Principal Areas of Disagreement Summary Statement (PADSS) from National Highways Limited (“National Highways”)

Application by Gloucestershire County Council (“Applicant”) for an Order Granting Development Consent for the M5 Junction 10 Improvement Scheme (“Scheme”)

Planning Inspectorate Reference Number: TR010063

Submitted at: Deadline 1 - 18 June 2024

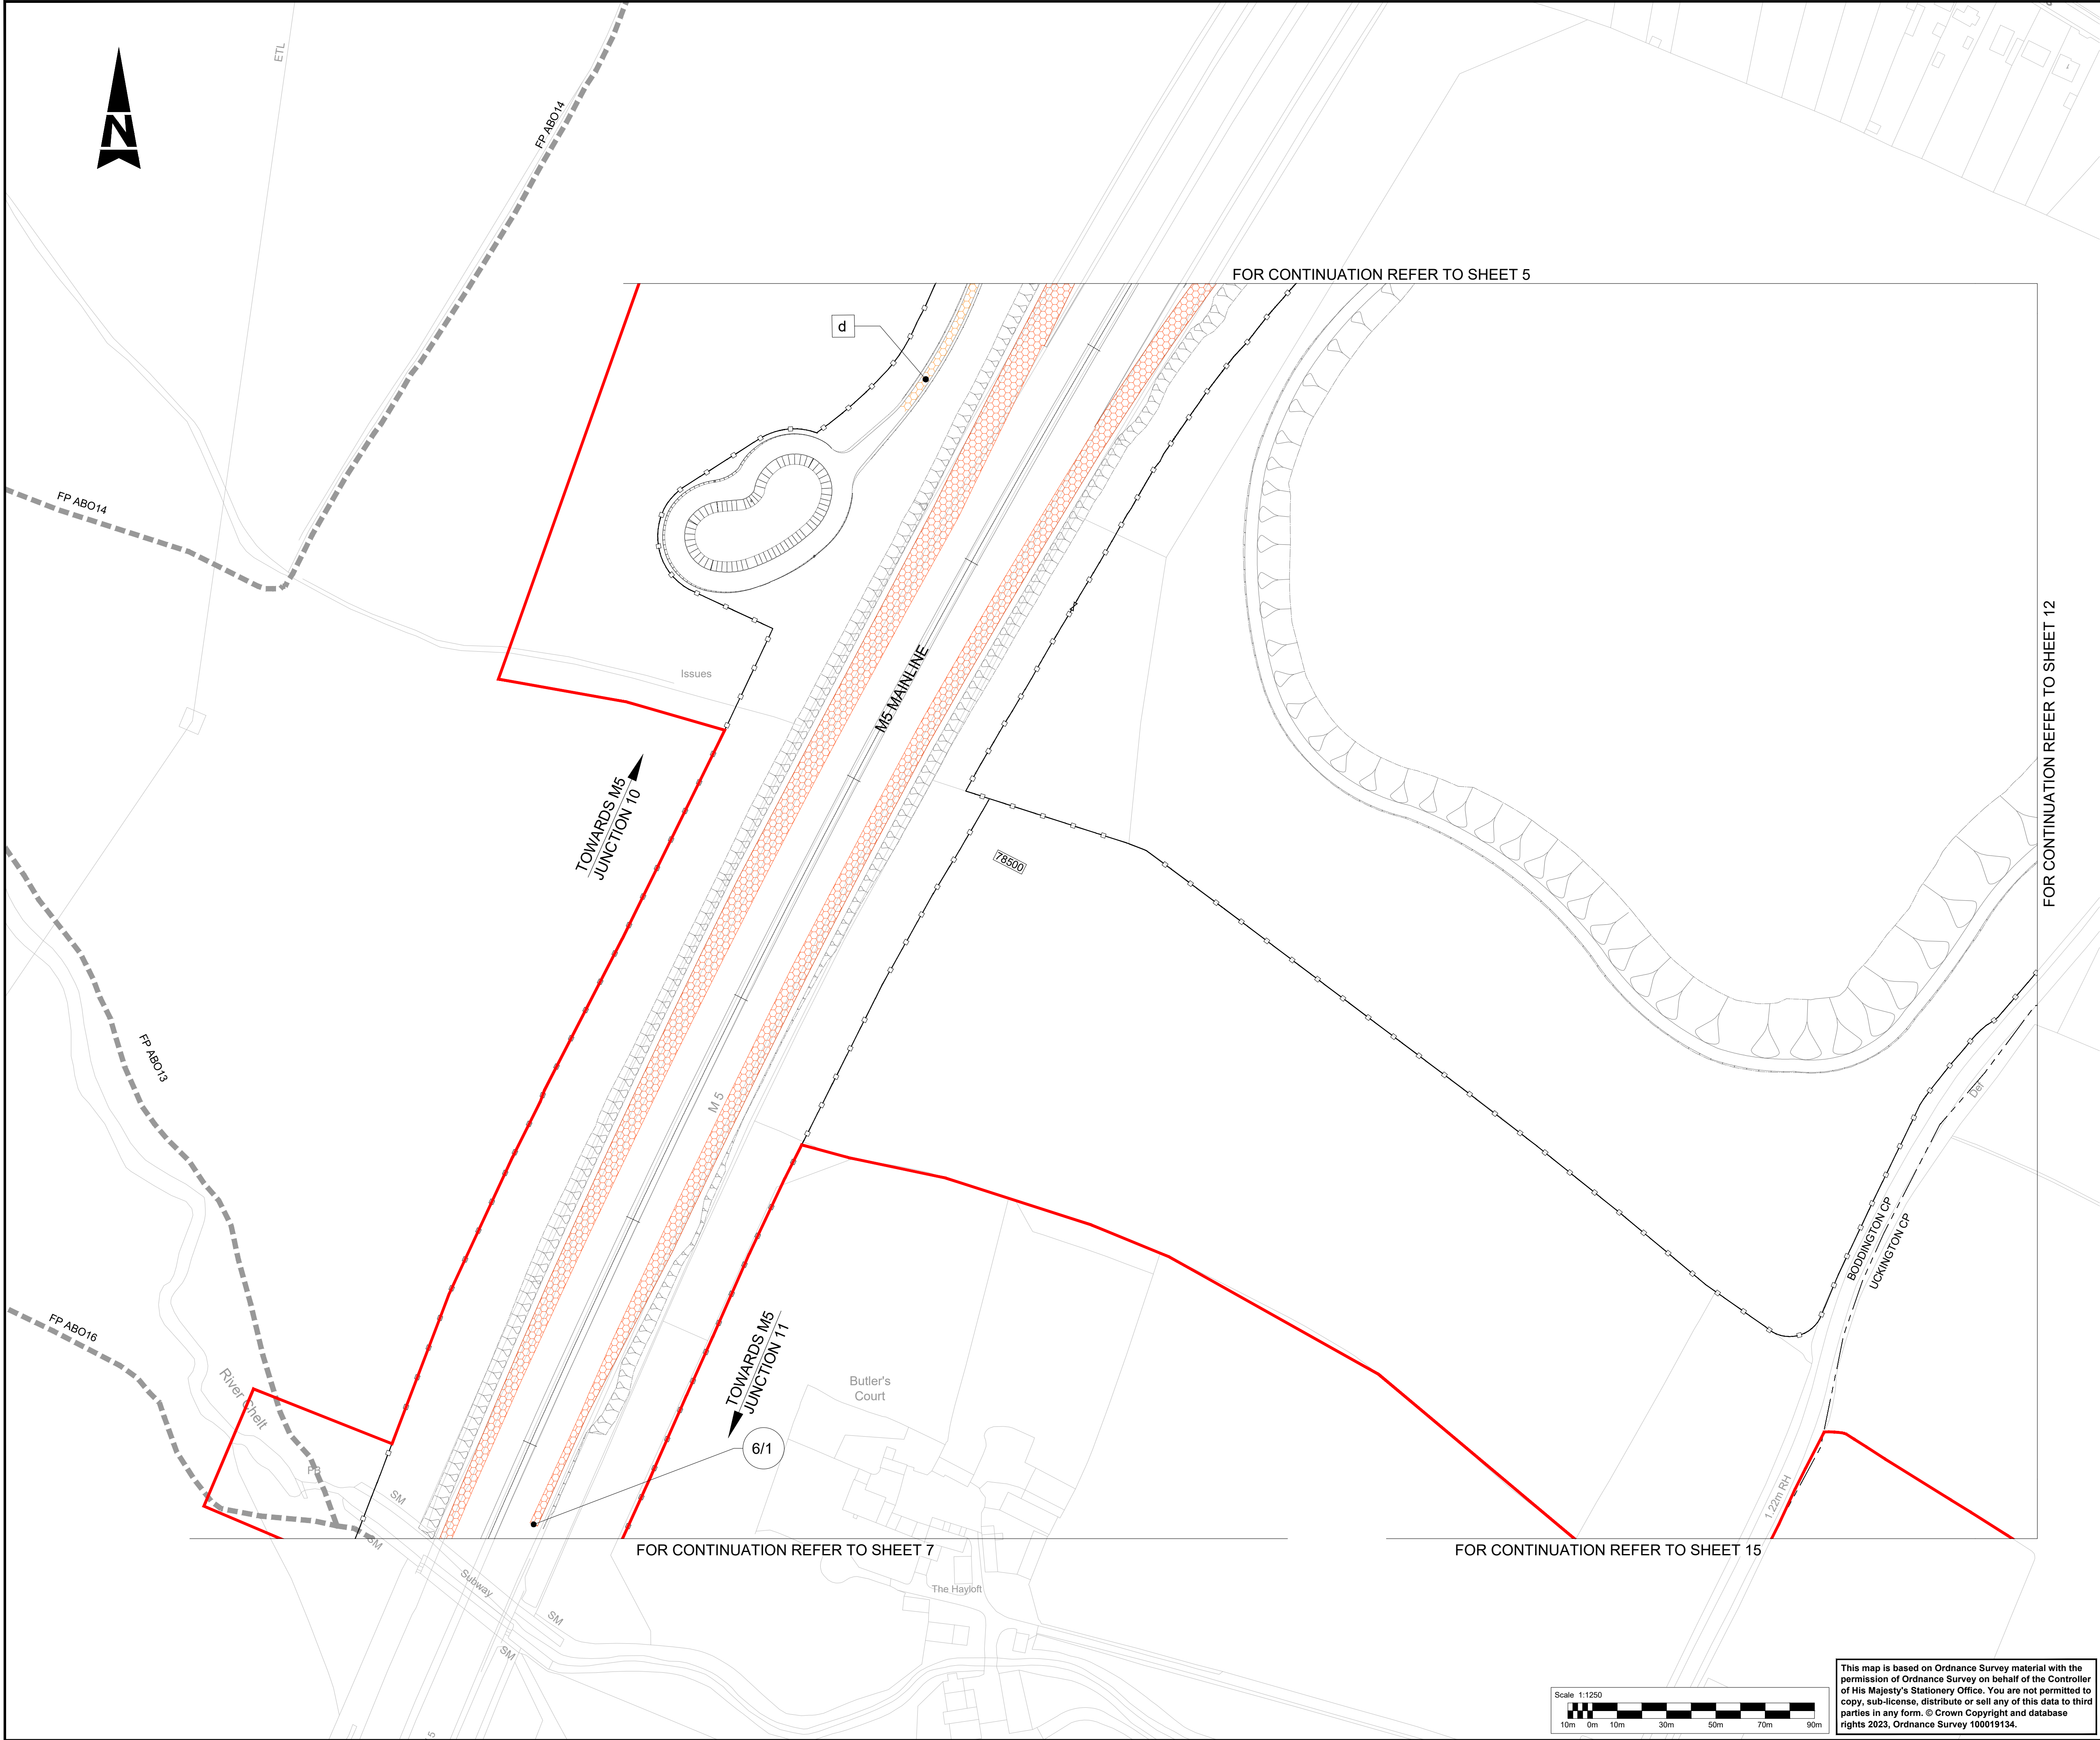
32.	Design	Omission of a viewport to show stopping up on sheet 5 of 16 of Street, Right of Way and Access Plans	National Highways requests that an insert to the drawings is added to show the stopping up of the old N/B on slip road under the junction overbridge.	High
